**Final Drainage Report Addendum
Peaceful Ridge at Fountain Valley Subdivision
El Paso County, Colorado**

May 2023

PCD File No. CDR-22-015

SHEET DRN 01

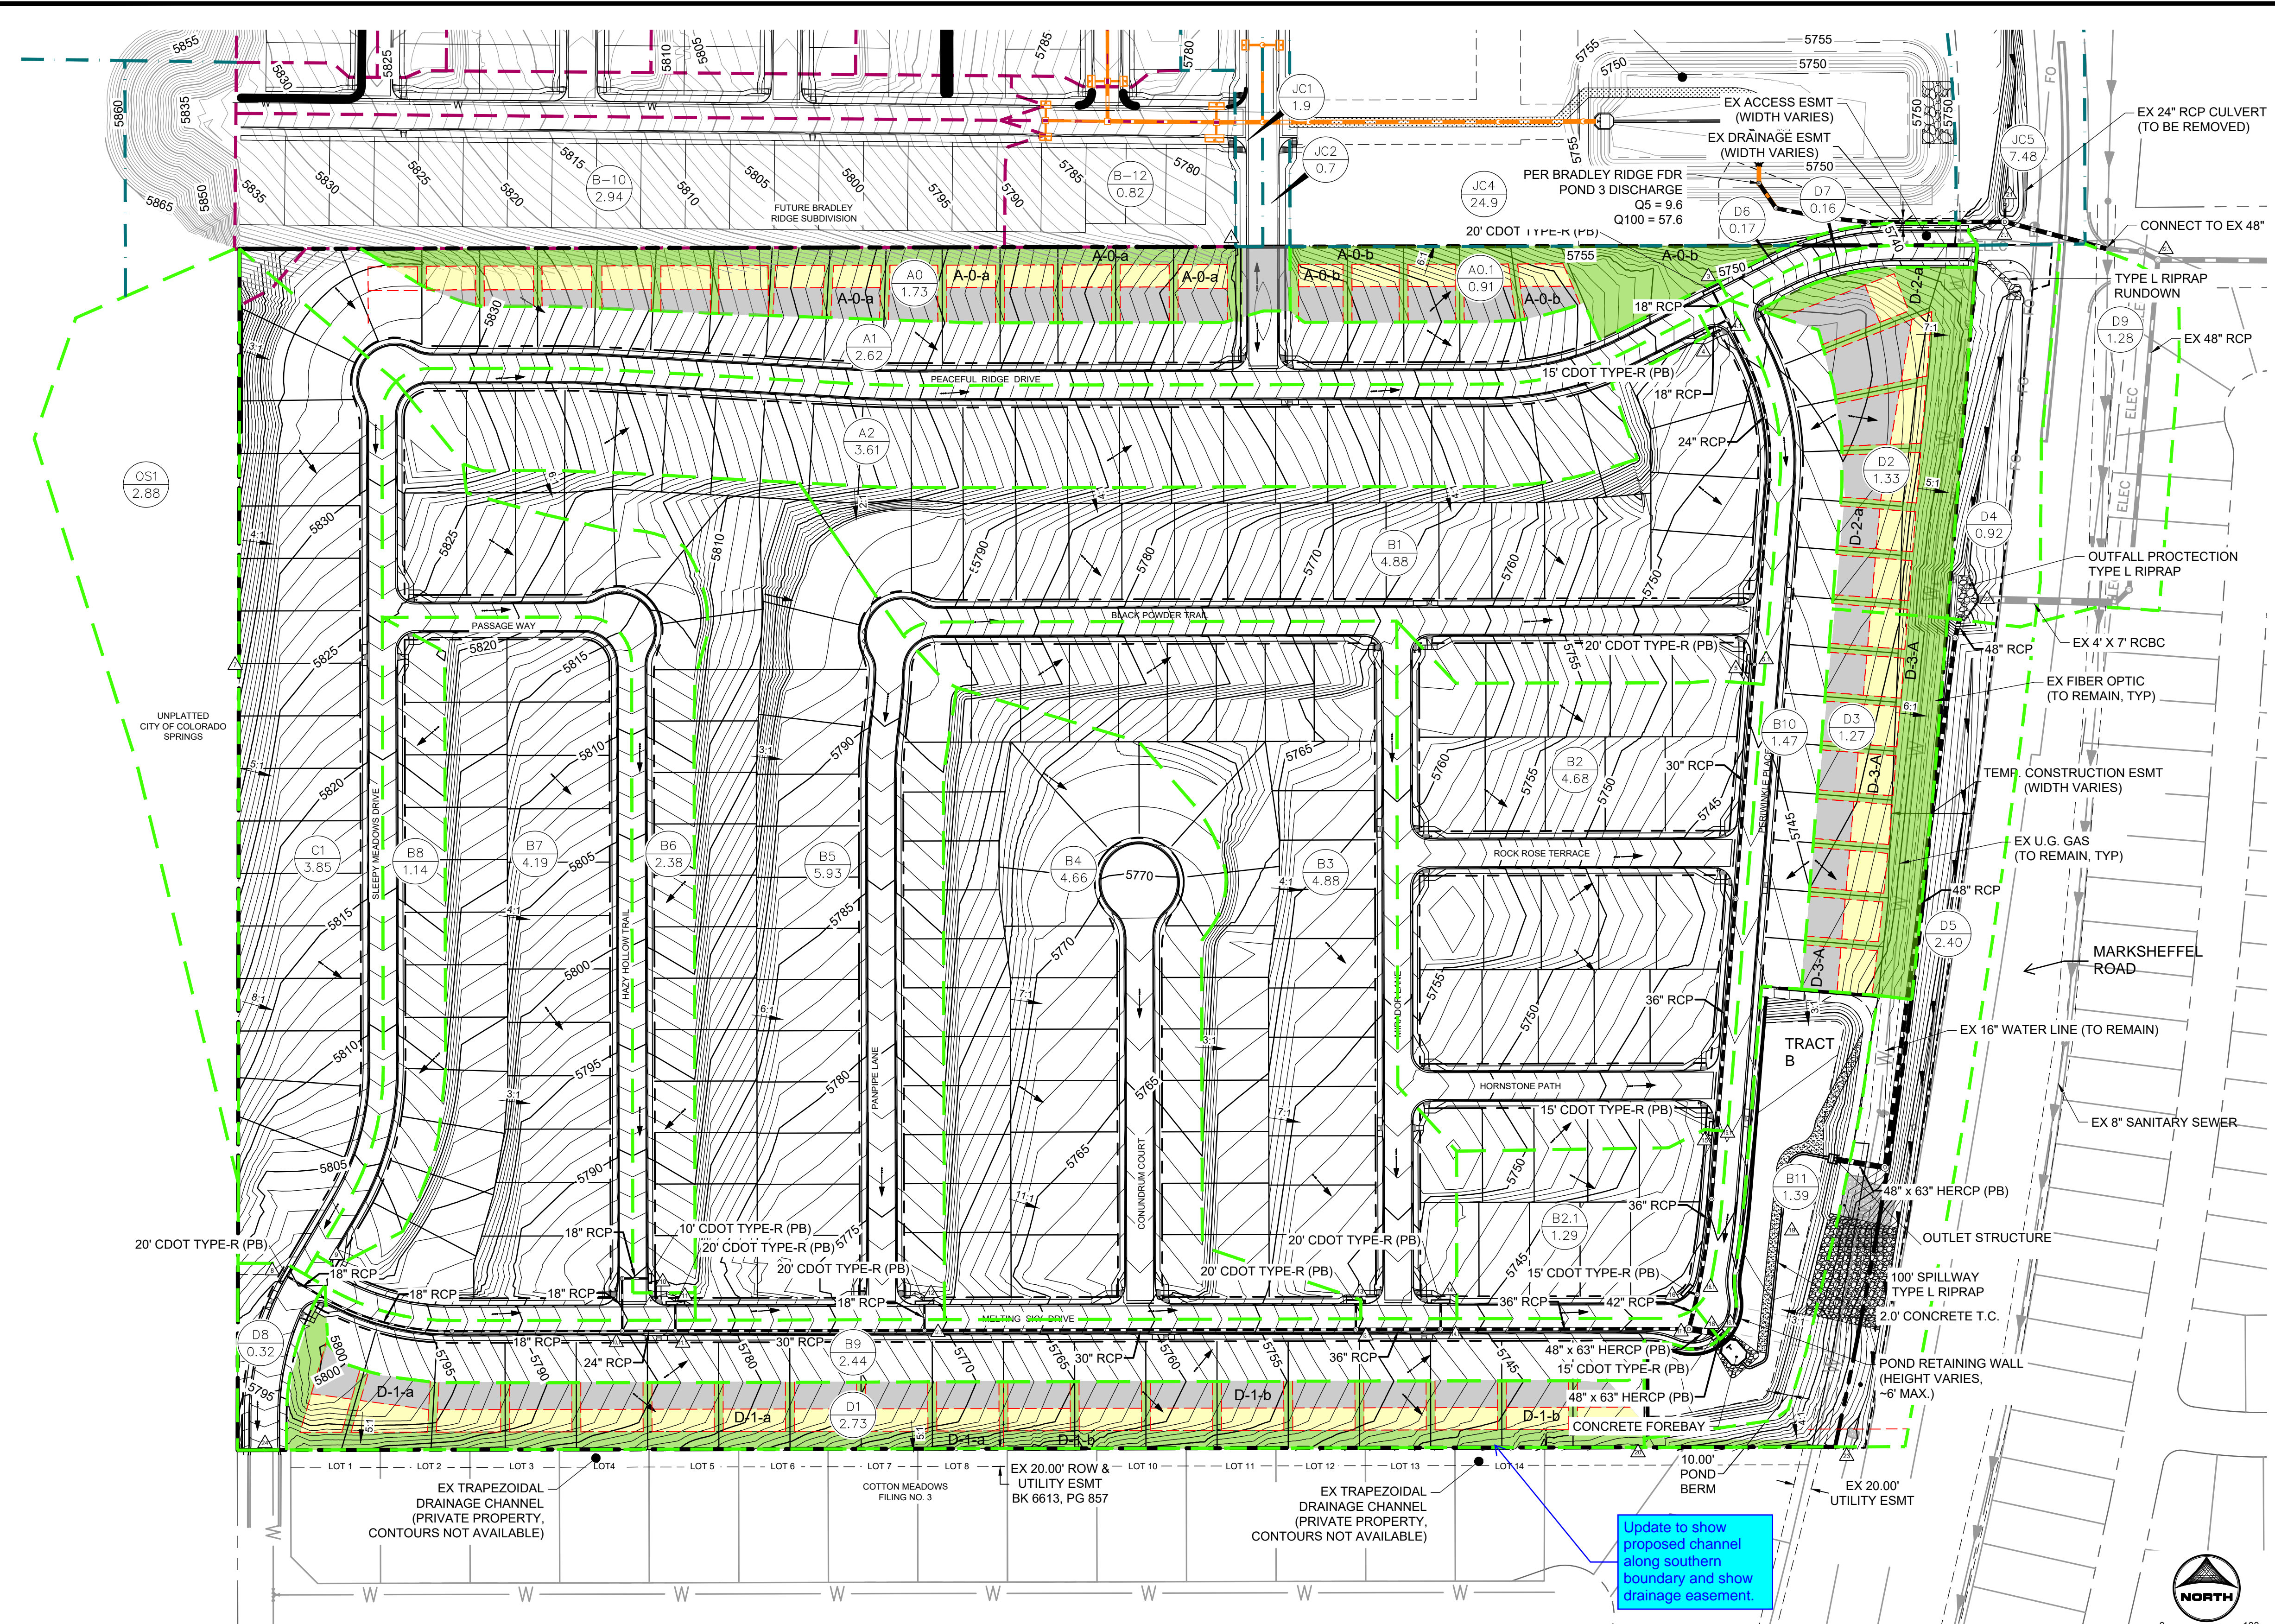
explain why the area decreased from 3.05 to 2.88 ac

Revise to identify how this subdivision's flow is flowing to Marksheffel Rd. Per ECM 3.2.4 a suitable outfall is necessary for developed flow, and that means a hydraulically adequate channel. Work with the Cottonwood Meadows neighbors to construct the recommended channel cross section.

Discuss whether flow destination will remain the same or if it is being diverted.
